From: [Plant, Tom - Communities](#)
To: [Sarah Greenall](#)
Cc: [DC Support](#); [Councillor Lawrie Stratford](#)
Subject: 19-01271-F - The Bothy Brashfield House Buckingham Road Caversfield OX27 8RE
Date: 13 August 2019 16:43:38
Attachments: [image001.jpg](#)

Planning application:	19/01271/F
Location:	The Bothy Brashfield House Buckingham Road Caversfield OX27 8RE
Description:	Replace the boundary fence adjacent to the foot path
Type:	Full Development
Case Officer:	Sarah Greenall

Date: July 2019	Scale: 1:100 @ A1	Drawn by: SPW
Dwg No: MA-191018-22		Rev: A

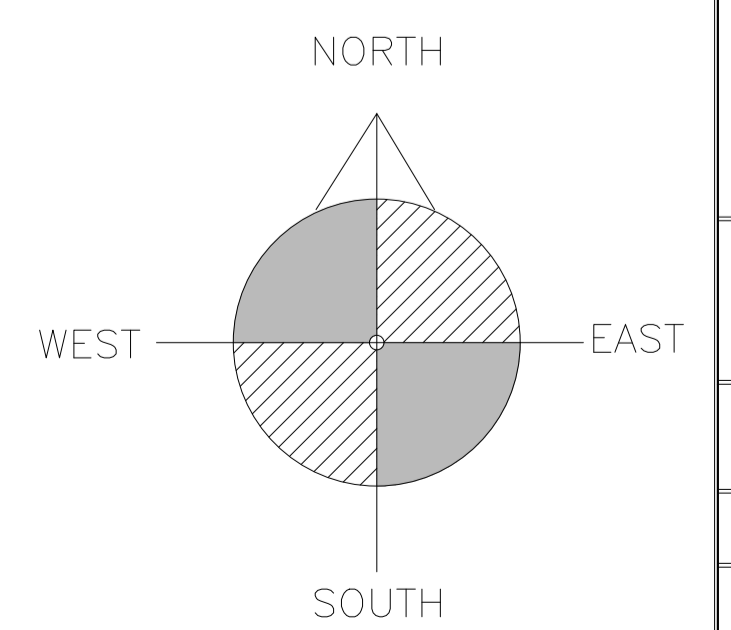
Prior to the first use/occupation of the development hereby approved, the parking and manoeuvring areas shall be provided in accordance with the plan approved (Drawing No. MA-191018-22 Rev A) and shall be constructed from porous materials or provision shall be made to direct run-off water from the hard surface to a permeable or porous area or surface within the curtilage of the site. Thereafter, the parking and manoeuvring areas shall be retained in accordance with this condition and shall be unobstructed except for the parking and manoeuvring of vehicles at all times. Reason - In the interests of highway safety and flood prevention and to comply with Policies ESD7 and ESD15 of the Cherwell Local Plan 2011-2031 Part 1 and Government guidance contained within the National Planning Policy Framework.
